CITY OF ALBUQUERQUE

April 29, 2025

Re: Taco Bell/Retail Development
1115 Snow Vista Blvd. SW
Traffic Impact Study
Engineer's Stamp dated 04-19-2025 (M09D012D)
TRANS-2025-00022

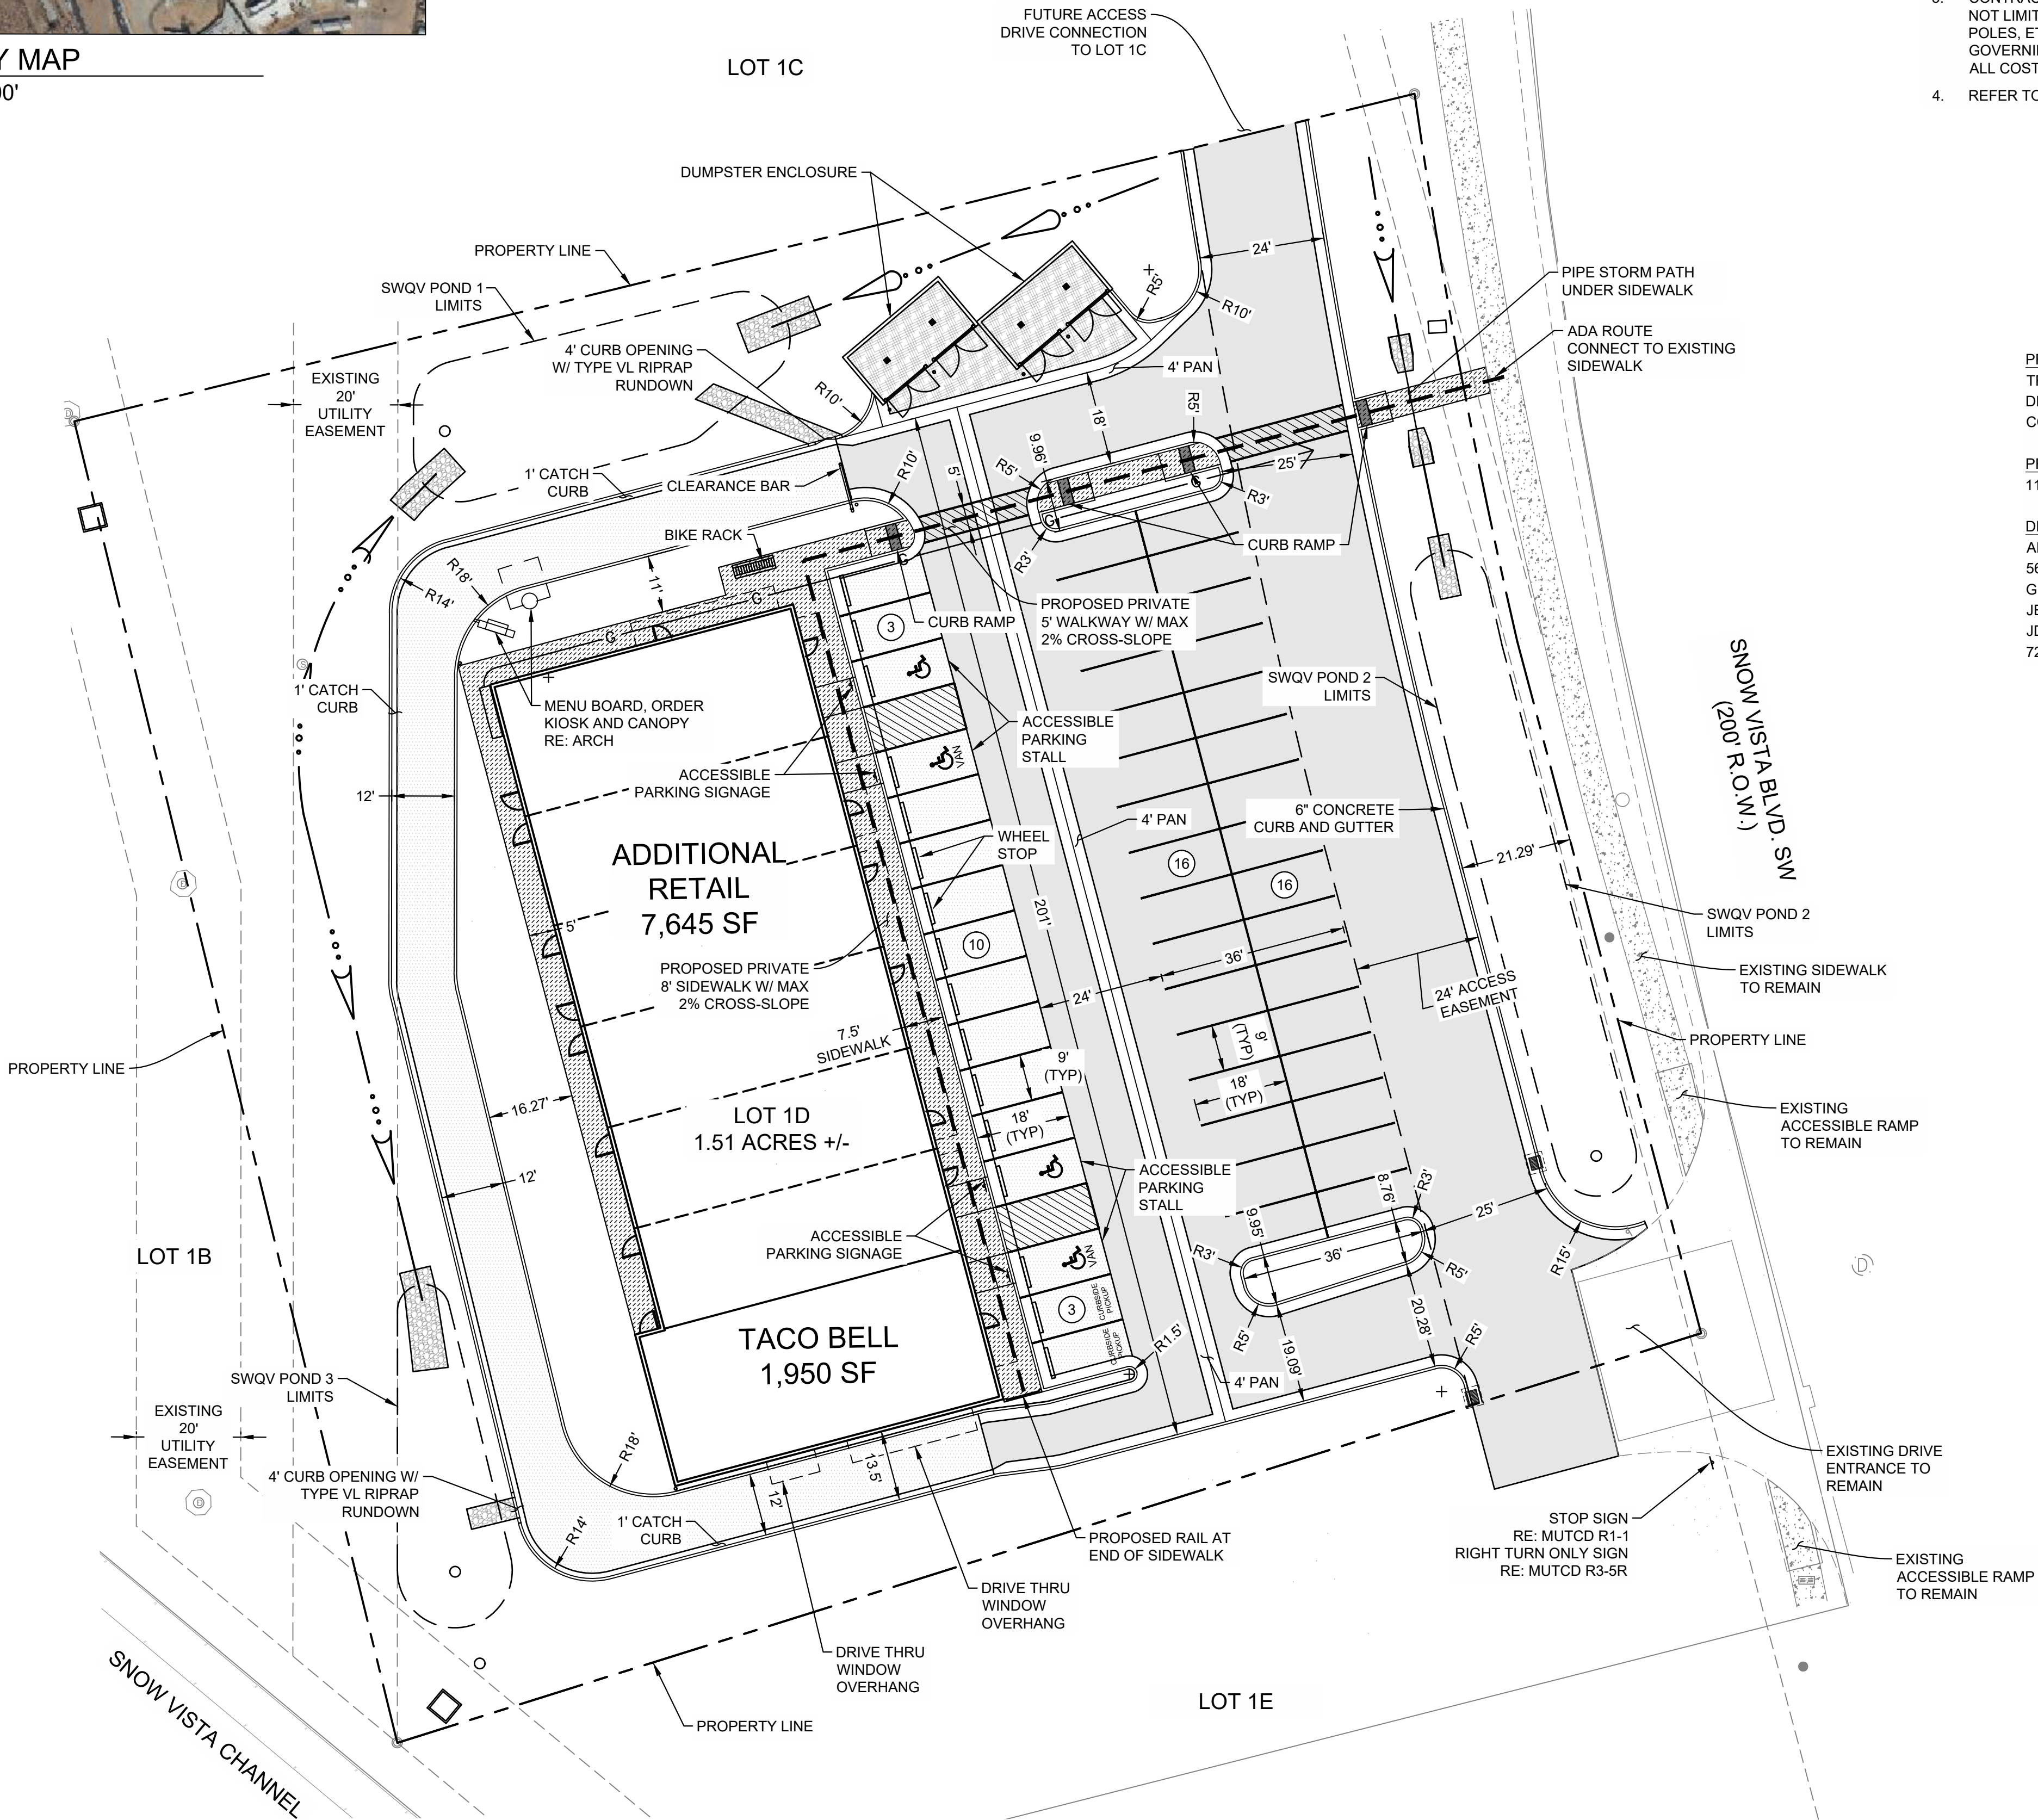
Based upon the information provided in your latest submittal received 04-25-25, has been reviewed and is approved by the City of Albuquerque Planning Development Department Transportation Section. Please ensure the TCL shows the propose "porkchop" at the entrance.
